ACCESS COMPLIANCE ASSESSMENT REPORT

Building Code of Australia 2022 Amendment 2

PROJECT:	461 Chapel Rd, Bankstown
REF. No.:	NEW241004 (Rev 7)
DATE:	12/02/2026
CLIENT:	Sustainable Development Group
CONTACT:	Richard Huynh
EMAIL:	richard.huynh@sdg.org.au
CONSULTANT:	Mauricio Vera
PHONE No:	0451 078 790
EMAIL:	mvera@newcrown.com.au

Level 1 floor plan showing location of evacuation routes.

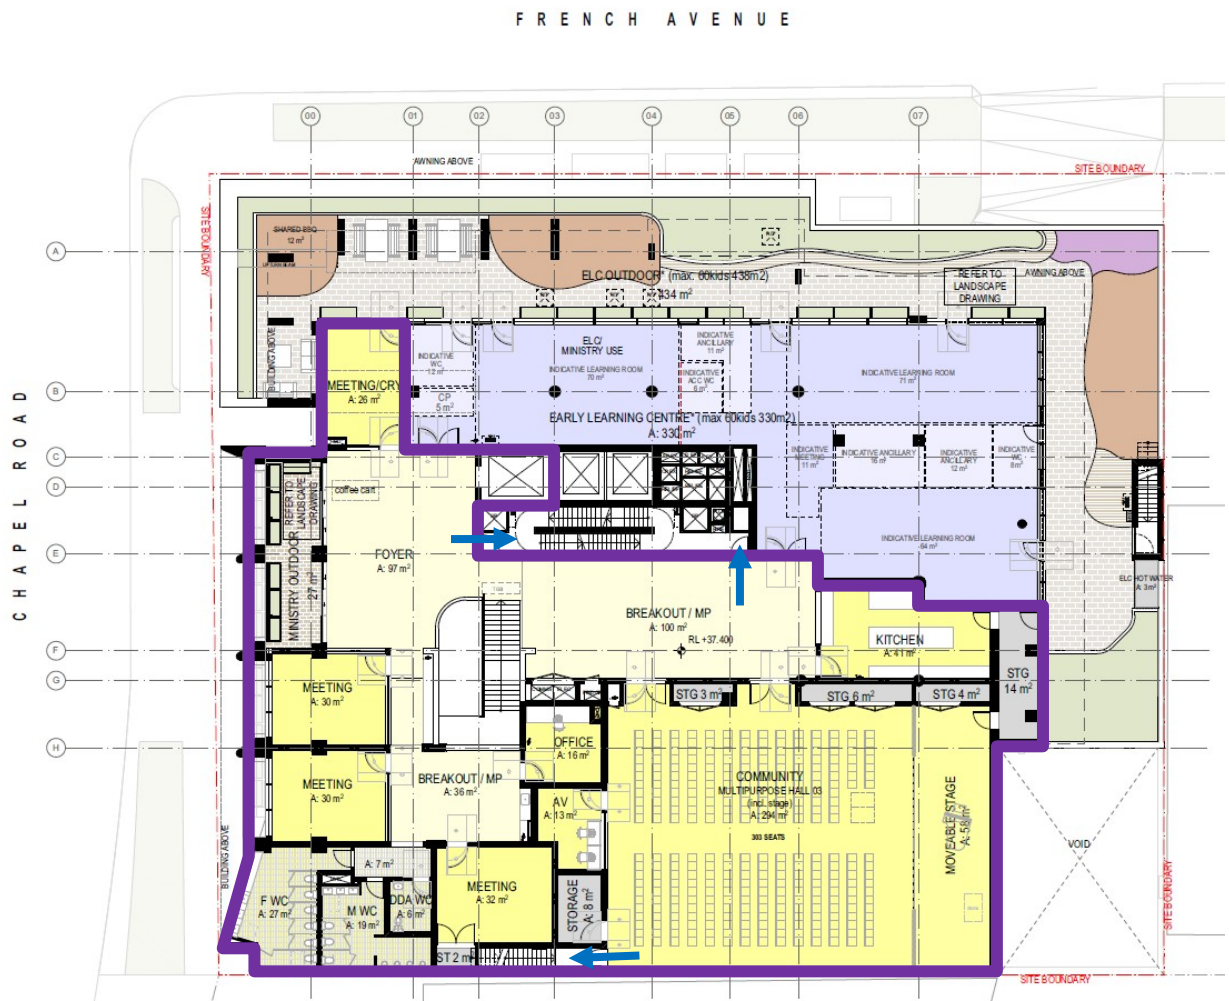
- Most of the corridors are provided with 1000mm clear width in compliance with this clause. However, some areas on Level 1 are identified with insufficient clear width of less than

1000mm, in non-compliance with this clause. **To be rectified, alternatively pursue a Performance Solution if feasible.**
